Howerton Services, PLLC
License # P-1716
3513 Cathedral Bell Road
Raleigh, NC 27614
(919) 270-3460

Subject: Romero Residence Addition
15 Classic Cove Court
Fuquay Varina, NC 27526
Plan Addendum Letter

ROMERO TRUSS
MODIFICATION

A NEW CANT. TRUSS ON EXISTING TRUSS
 SCALE: 1" = 1'-0"

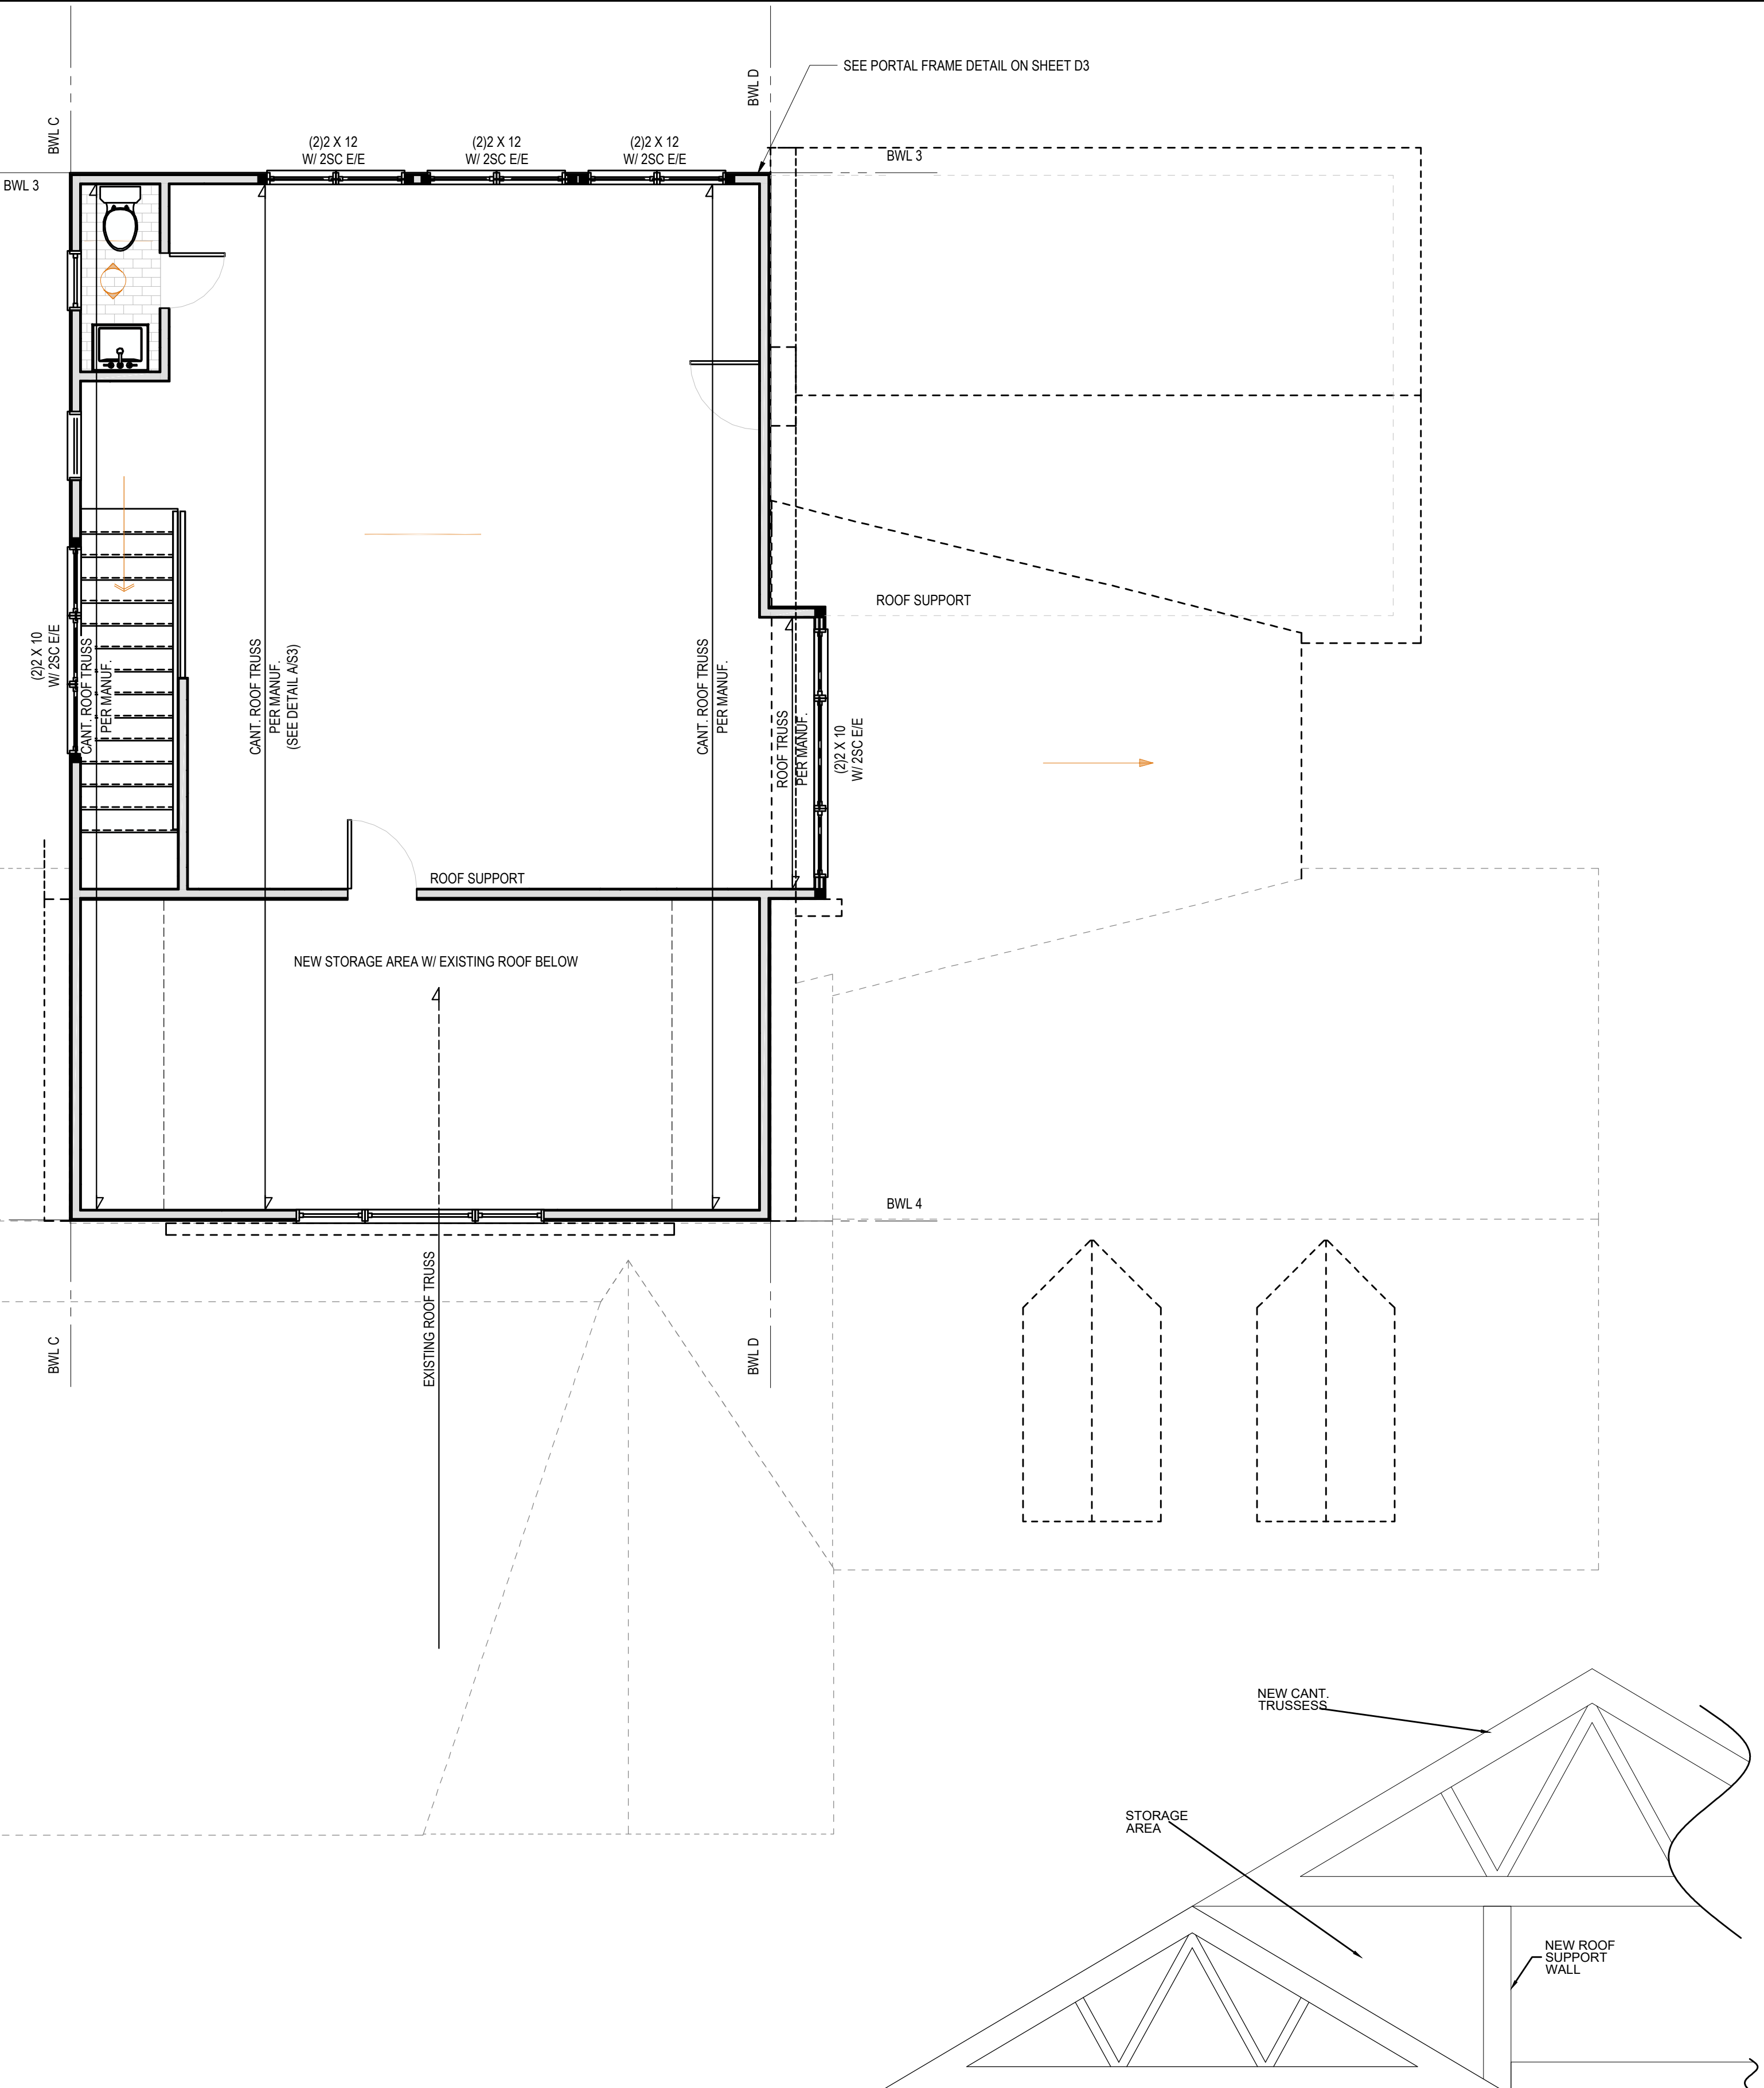
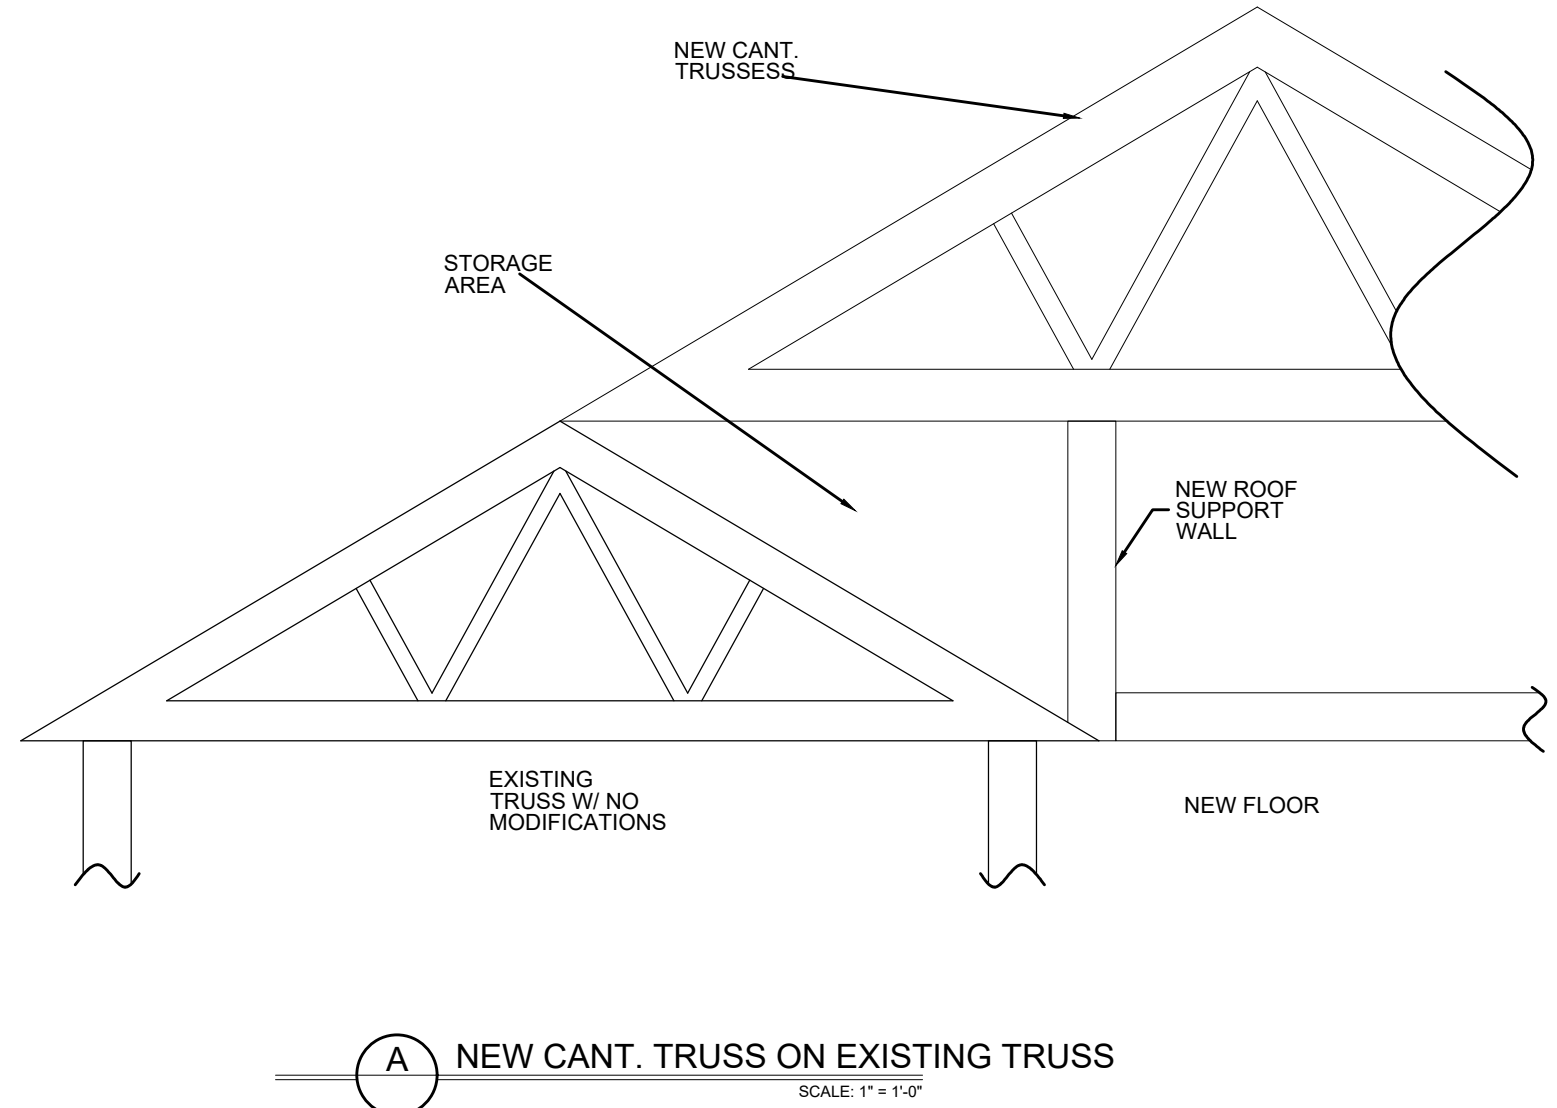
Based on the request of the Homeowner, I reviewed the plans for the addition. Some of the proposed framing will bear on existing roof trusses. To bear the load of the proposed construction, the trusses will need to be supplemented. My recommendations are as follows:

- Where the new dormers bear on the existing trusses over the Garage, new 2x4 members will be added between the rafter members of the trusses spaced at 12" centers. Fasten the new 2x4 to the rafter member with 2 – 16d common nails or 3" screws.
- Where the roof of the 2nd floor addition bears on the existing trusses over the main section of the house, ½" OSB plywood will be added to the side of each truss as shown in the attached detail. Fasten the OSB plywood to the truss members as prescribed in the detail.

FASTEN $\frac{1}{2}$ " OSB TO EACH SIDE
OF THE EXISTING TRUSSES WITH
CONSTRUCTION ADHESIVE AND $1\frac{1}{2}$ " NAILS
OR SCREWS SPACED AT 8" CENTERS
